## **3030 St. Joseph Boulevard**

Planning Rationale Addendum No. 1  
Official Plan Amendment + Zoning By-law Amendment + Site Plan Control  
March 18, 2024

Prepared for 3030 St. Joseph Inc.

Prepared by Fotenn Planning + Design  
396 Cooper Street, Suite 300  
Ottawa, ON K2P 2H7

GROUND FLOOR

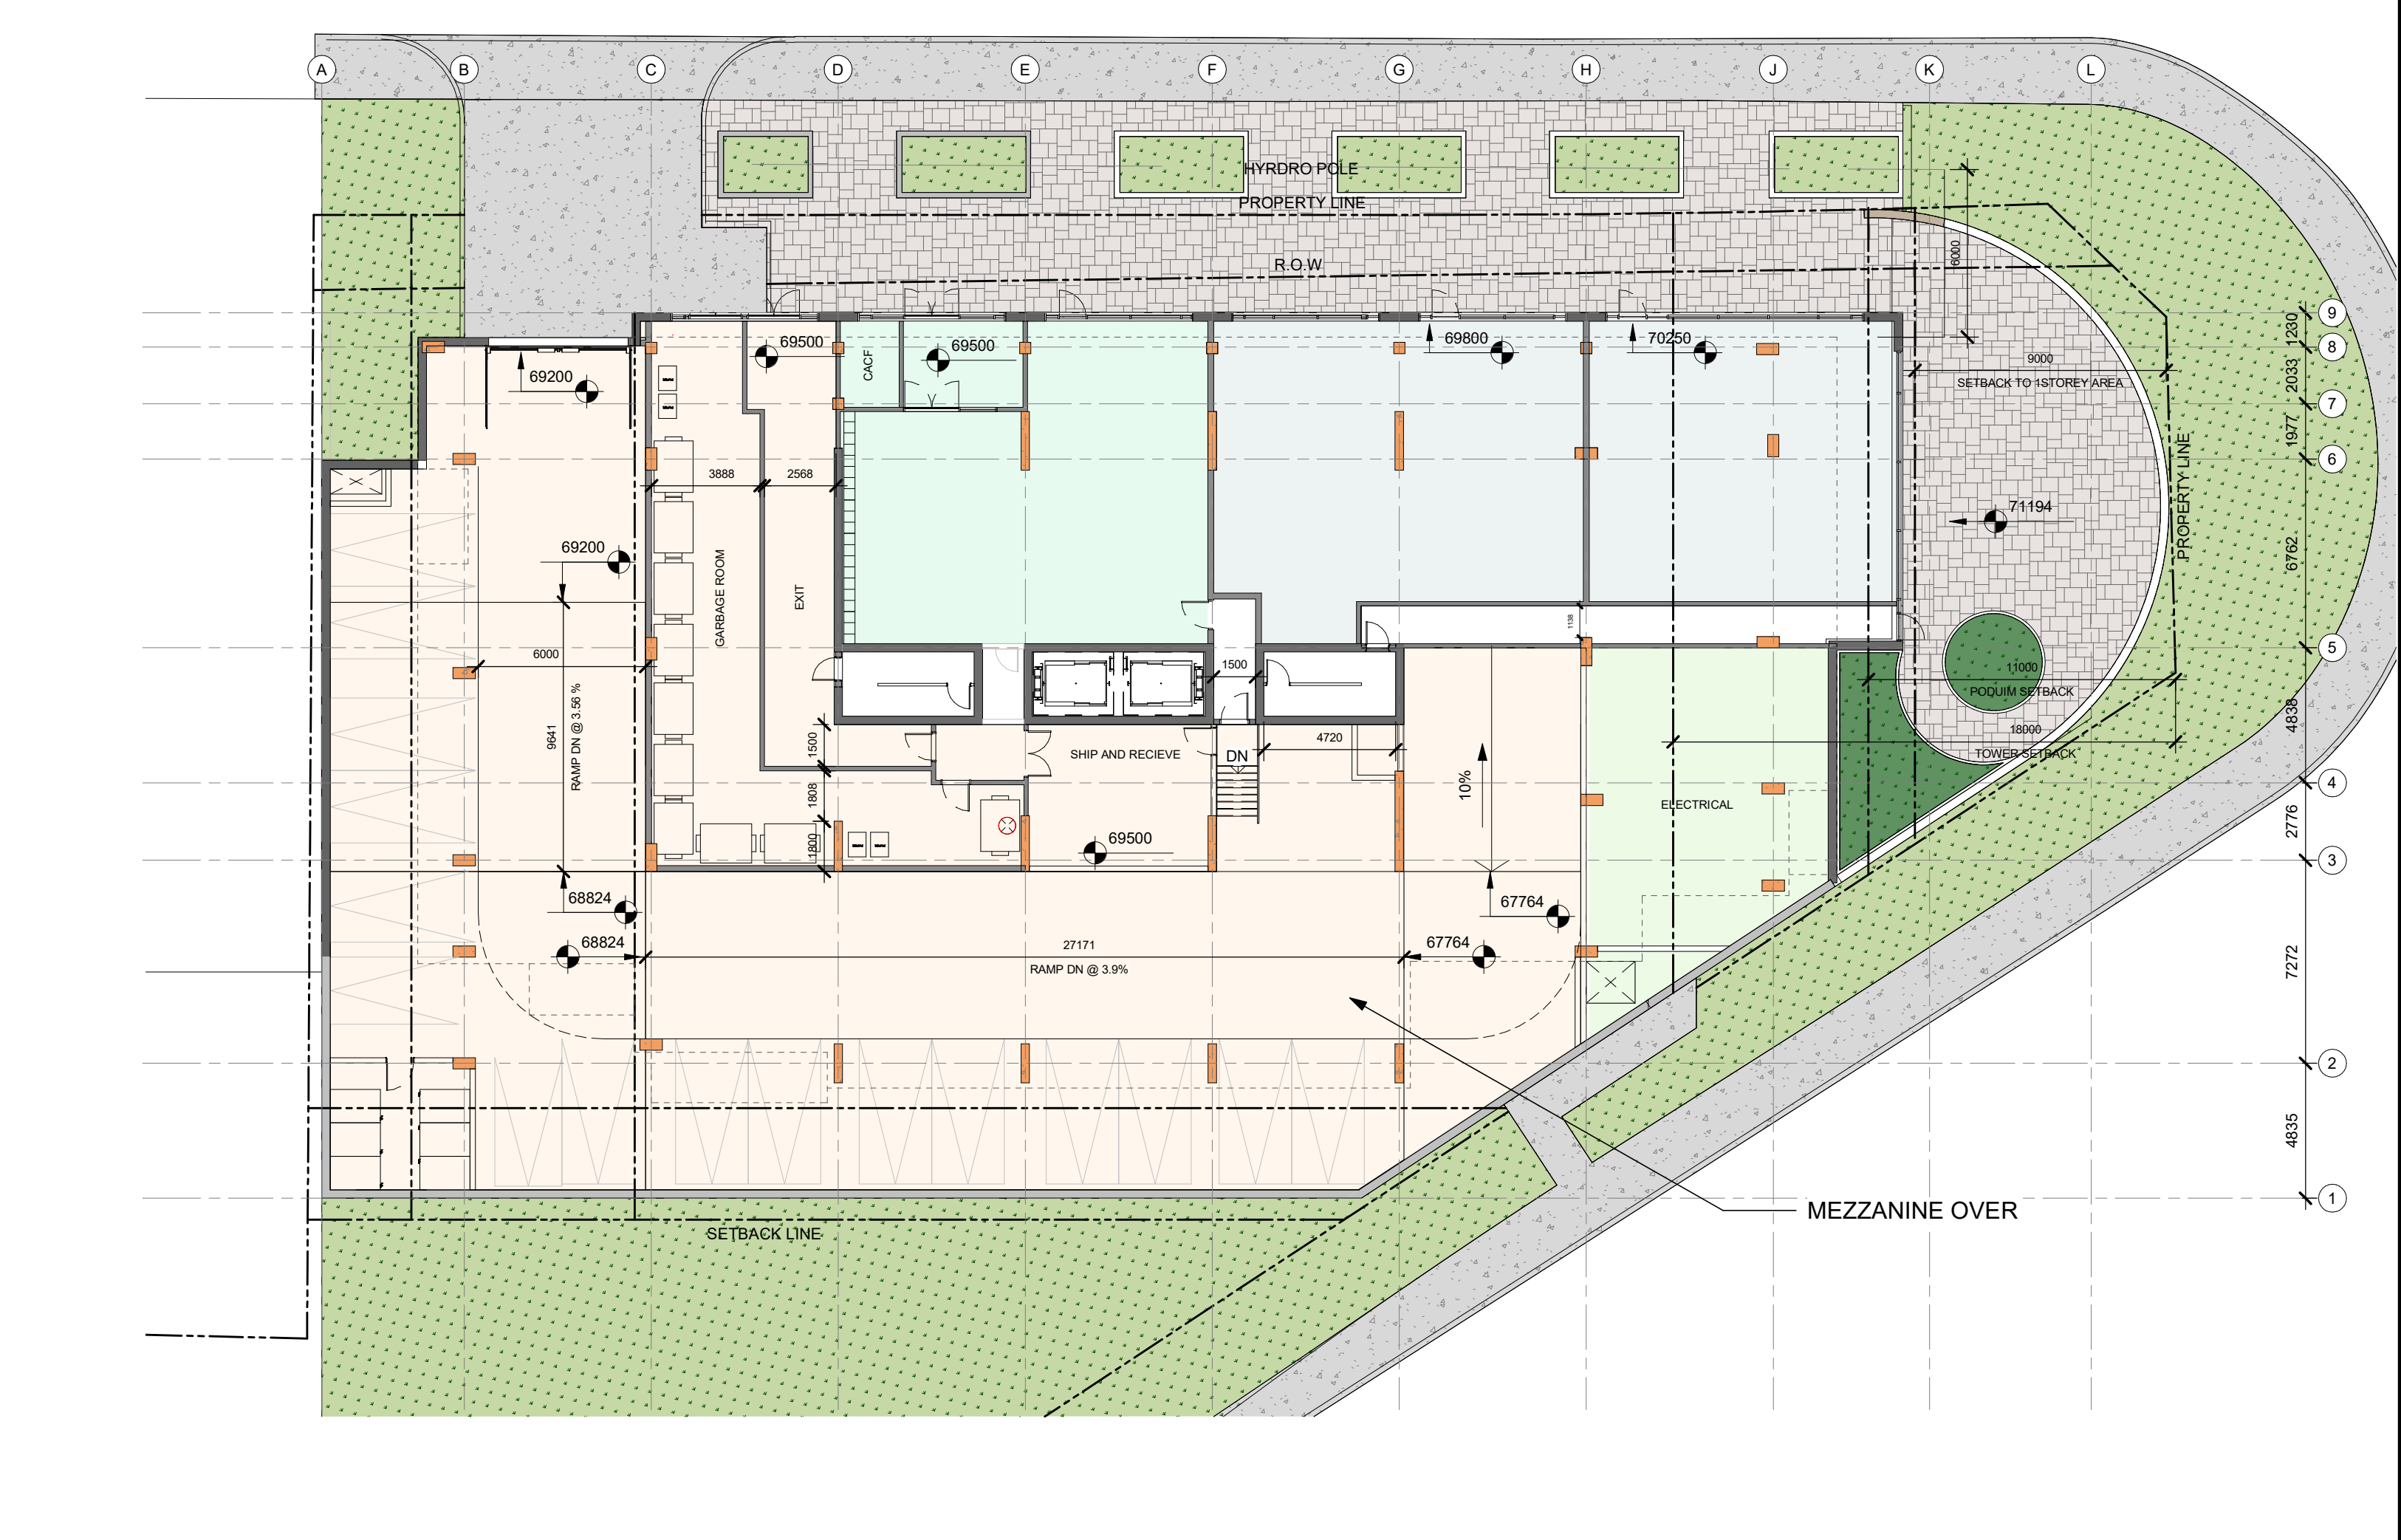
- / **Revised parking garage layout**, including a drop-off area due to anticipated carshare, taxi, food delivery, and courier short-term pick-ups and drop-offs. The design has been tested with a truck turning template. The ground floor façade has been simplified, with fewer setbacks, and the parking garage is now set deeper into the building to provide for delivery parking within the property;

ELEVATIONS

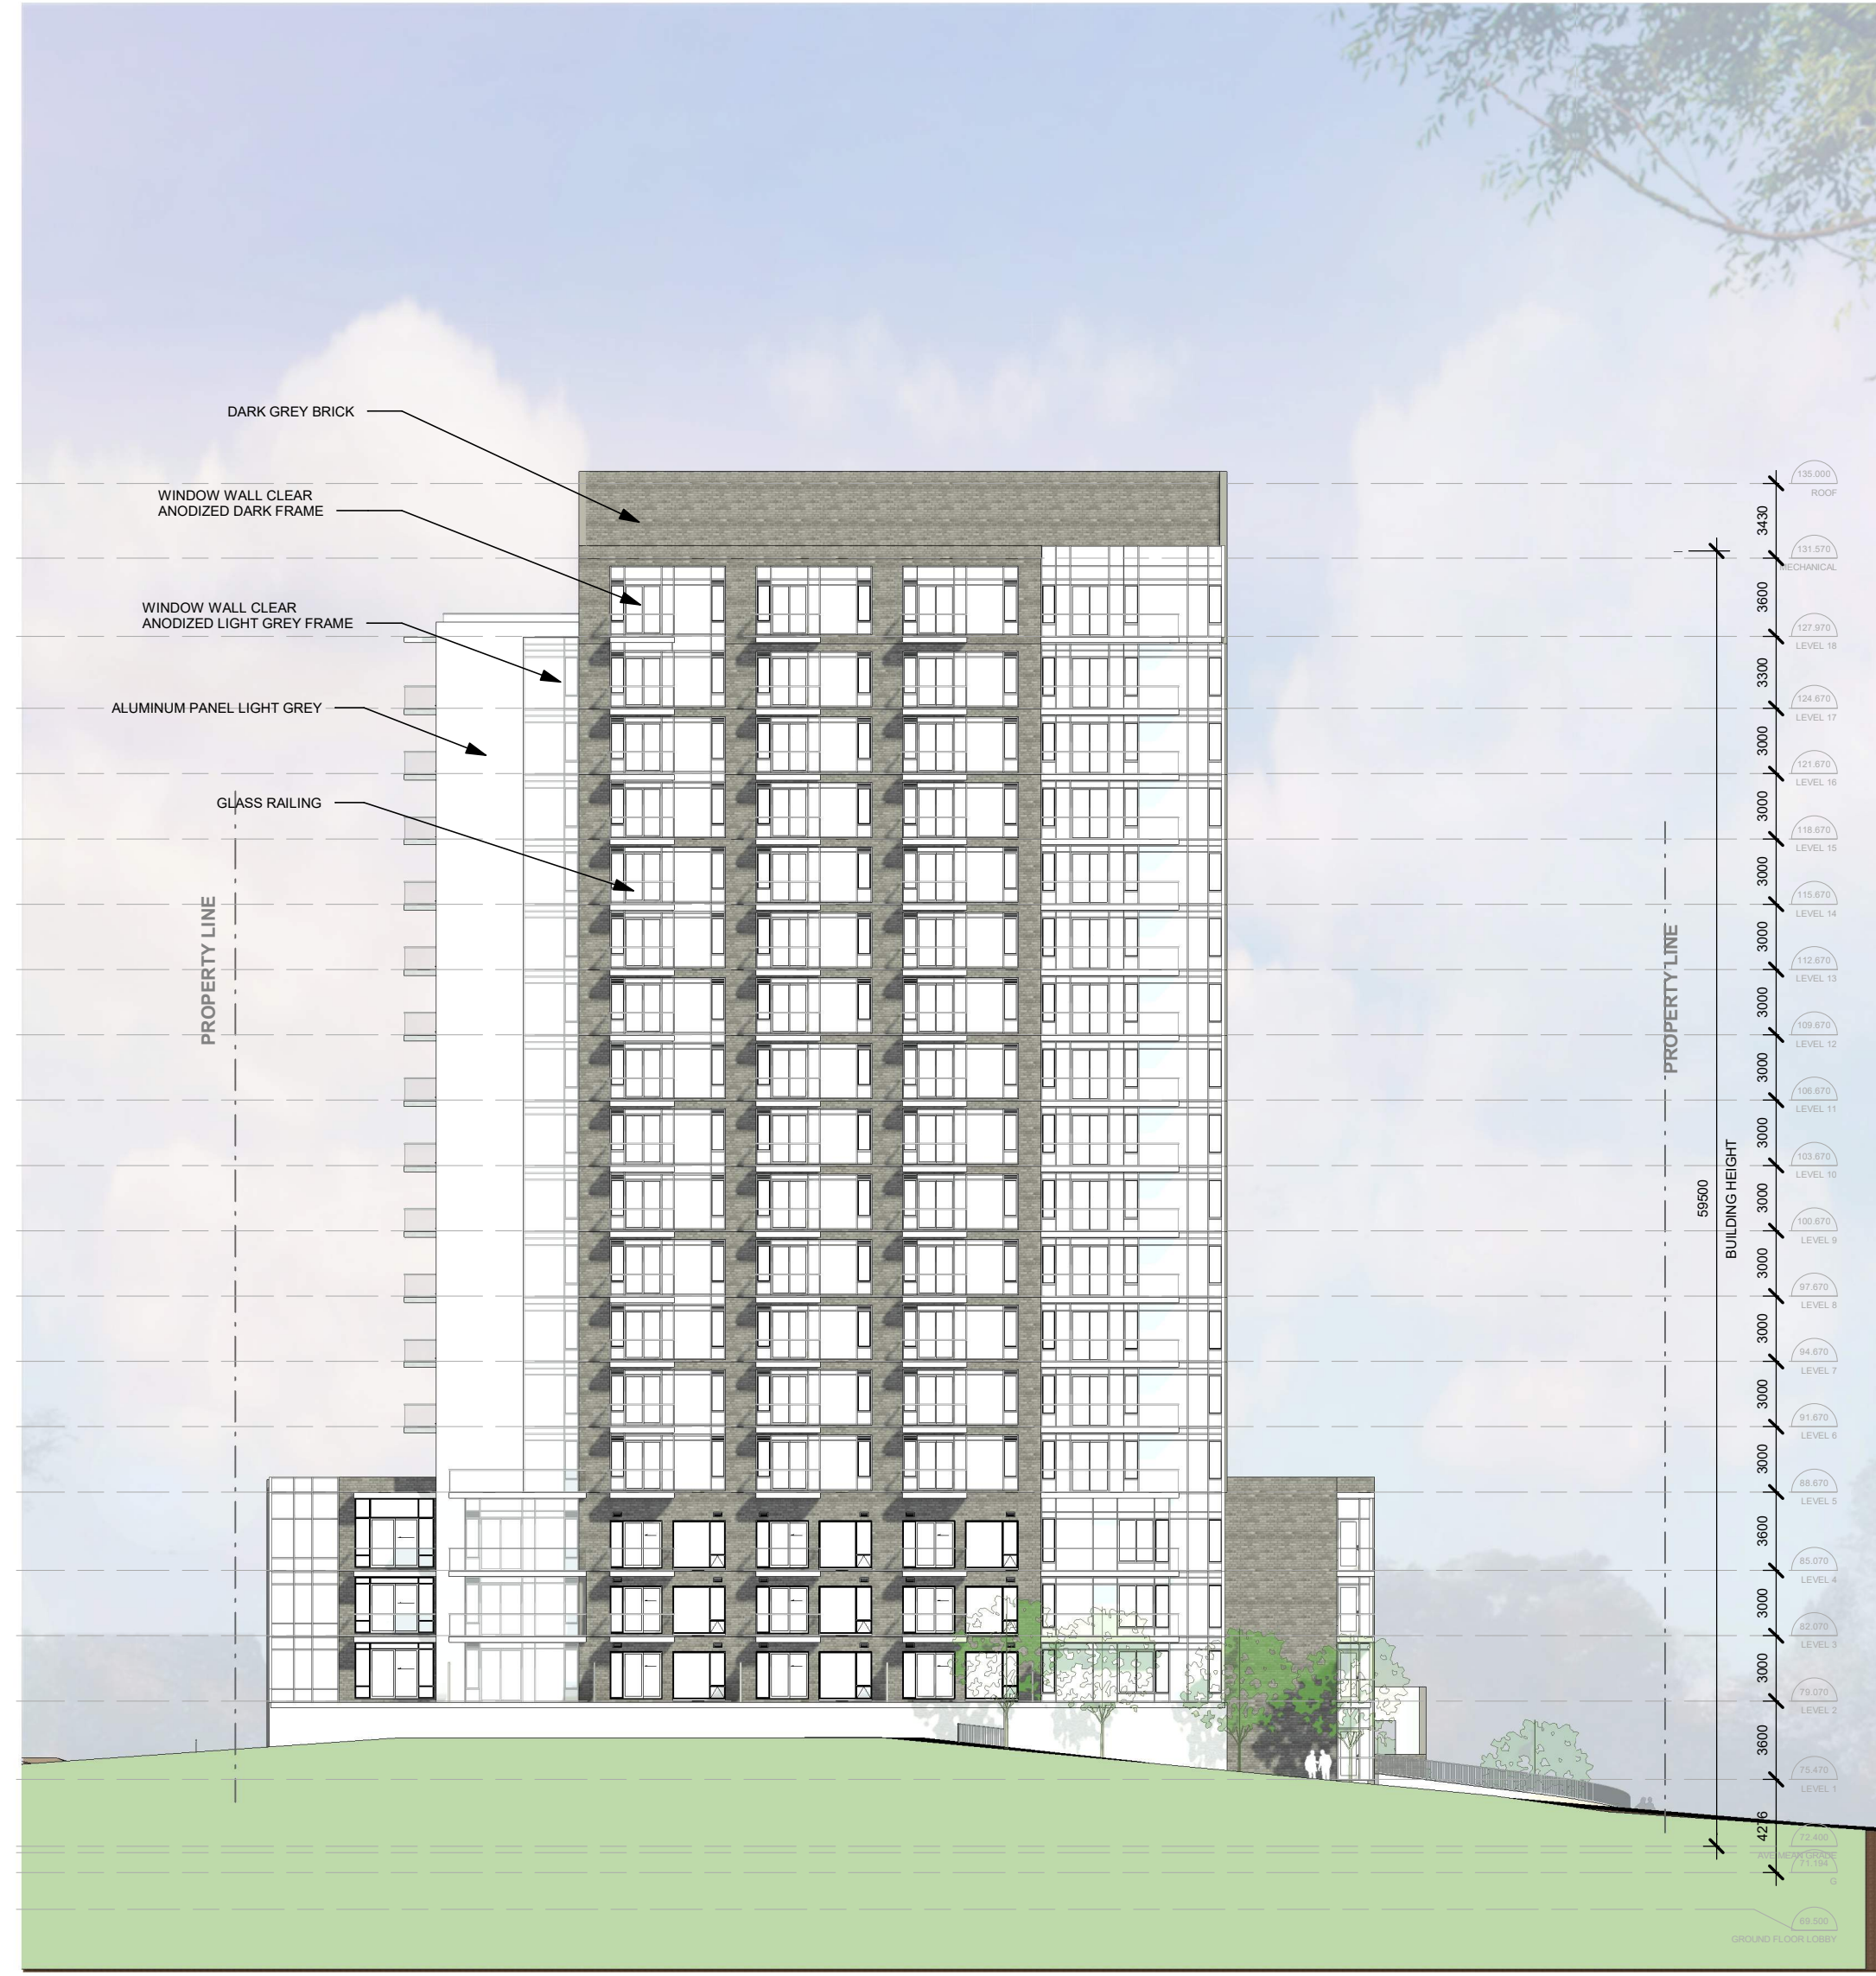
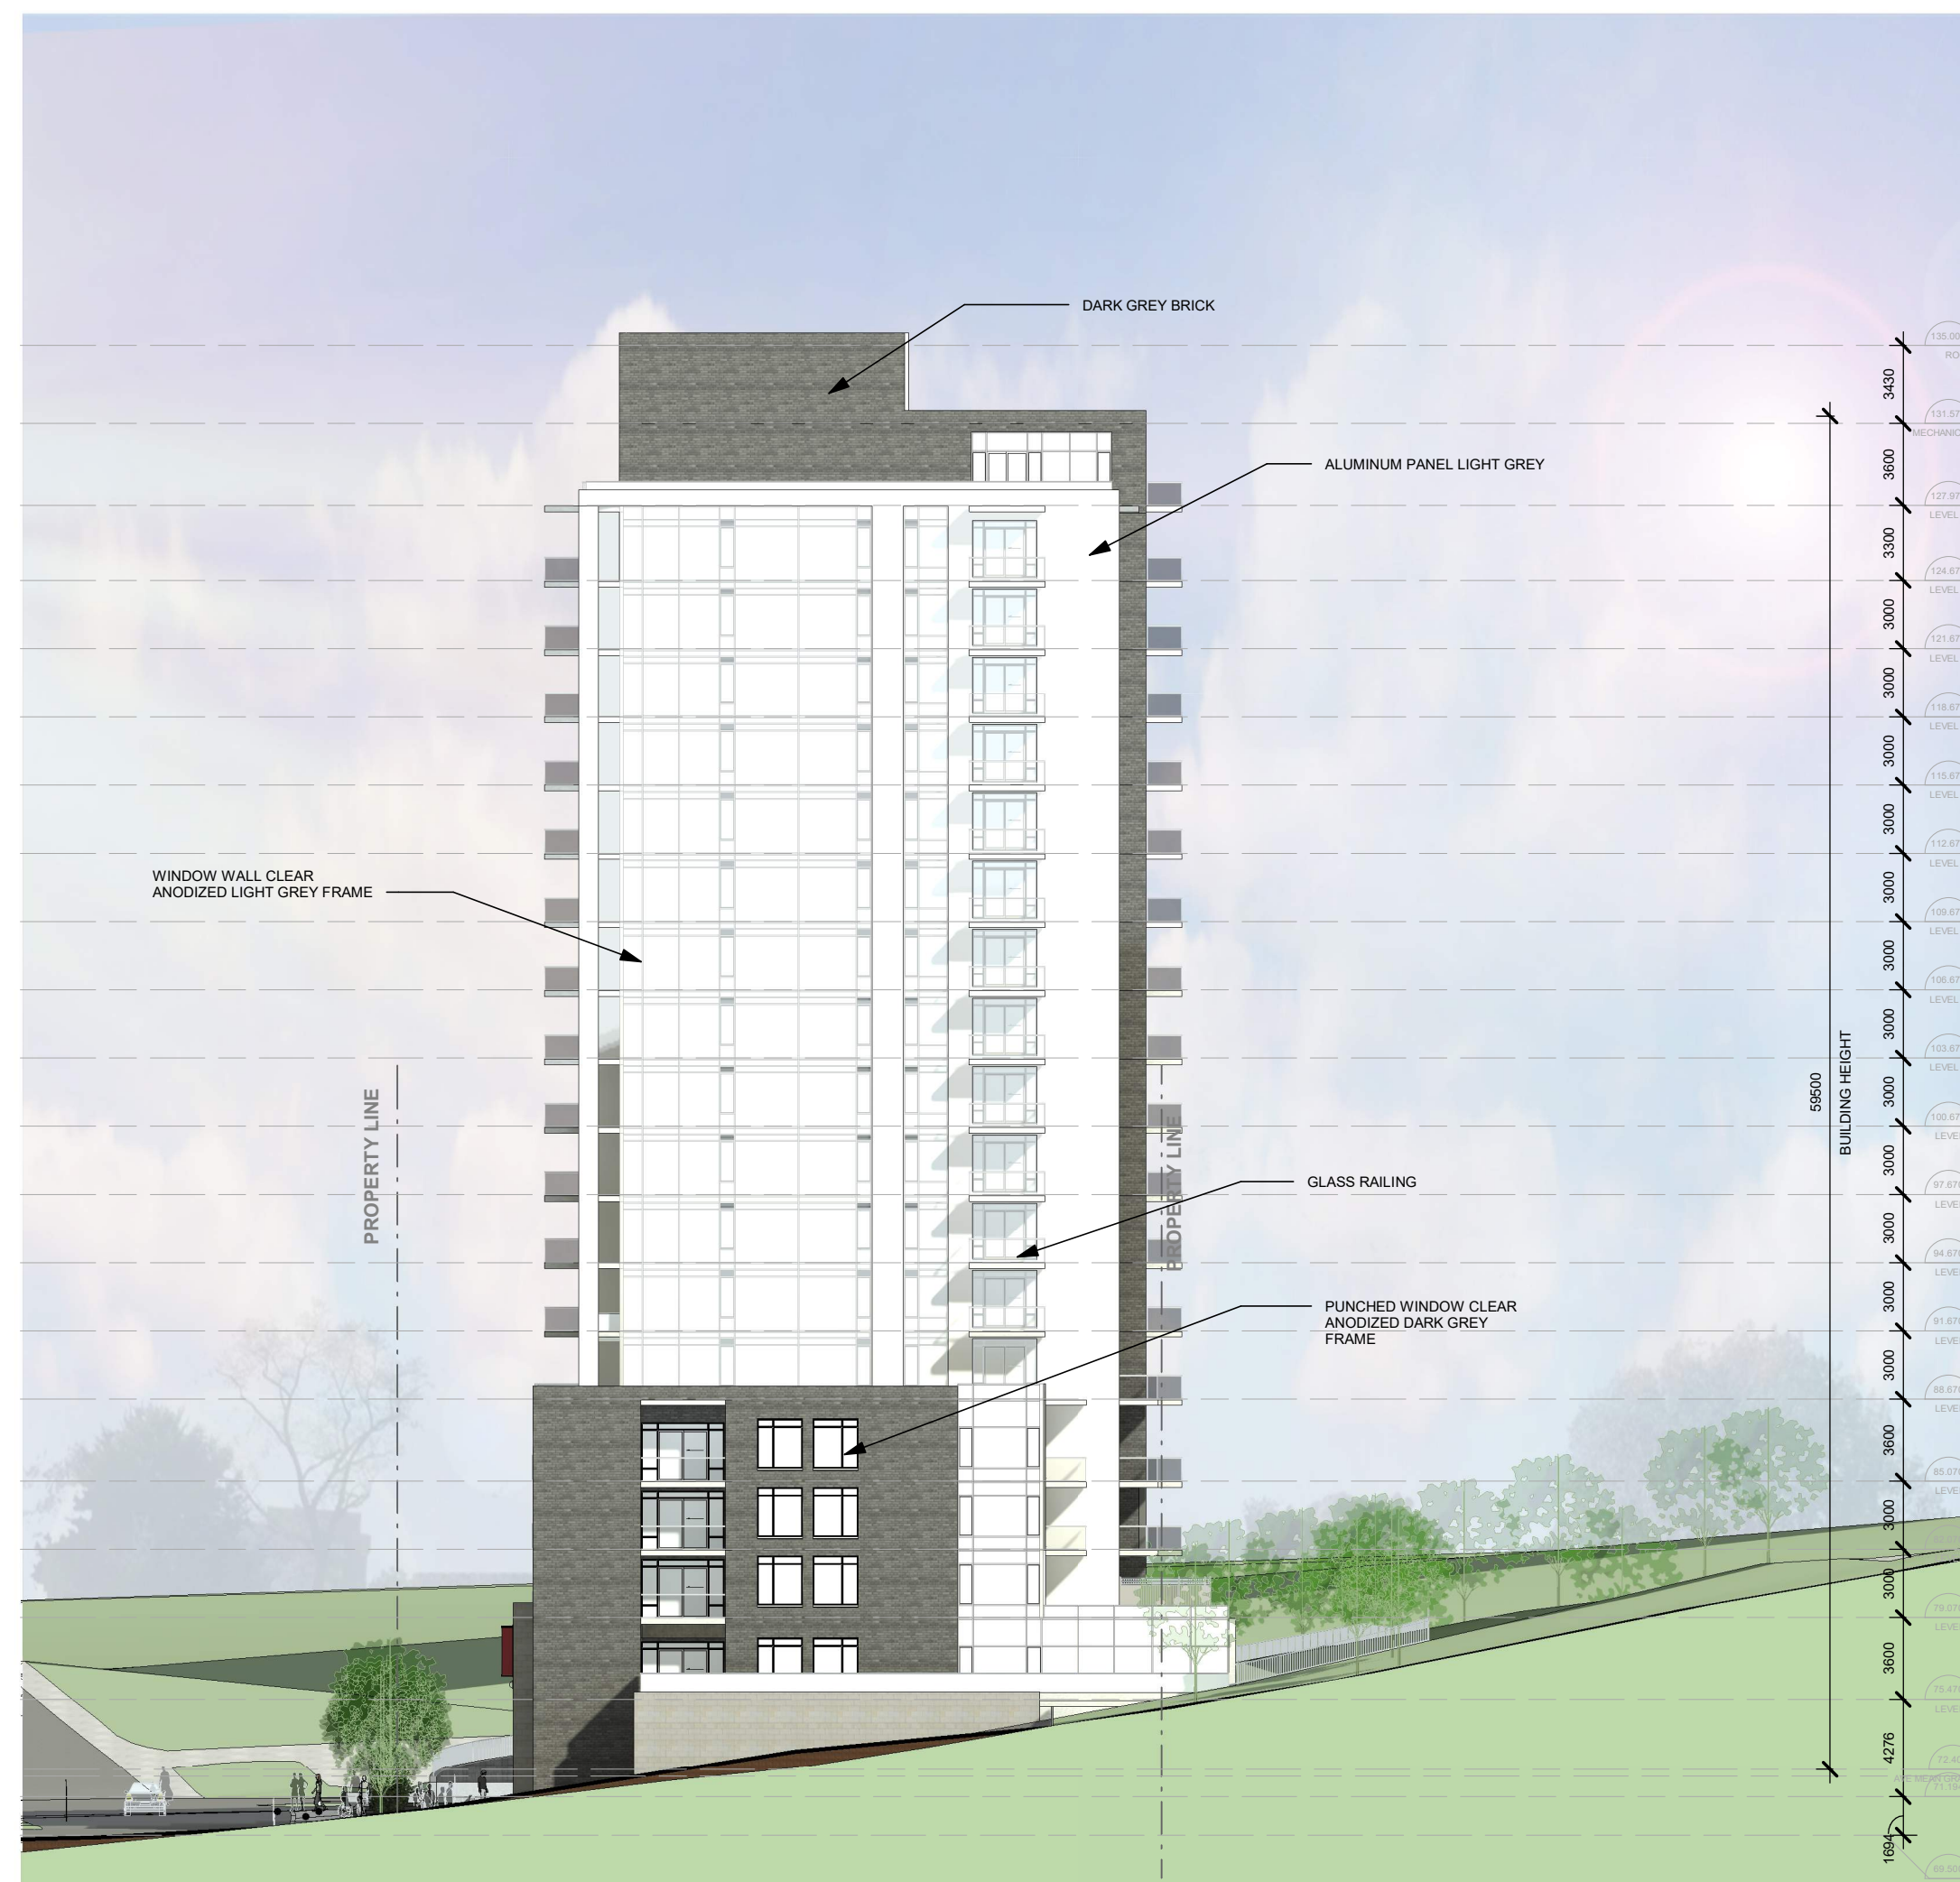
/ **Changes to the Building Design:** various elements of the building design have been adjusted resulting from comments from the Urban Design Review Panel. Changes include:

- Adding additional masonry has been added to further differentiate the podium massing to that of the tower;
- Elimination of glass in multiple areas, such as by replacing glassy expanses with punch windows, which improves the building's responses to the Bird Safe Design Guidelines;
- Higher contrast between the glass and other materials, which also improves the building's response to the Bird Safe Design Guidelines;
- Relocation of some balconies from the north façade facing St. Joseph Boulevard to the west façade;
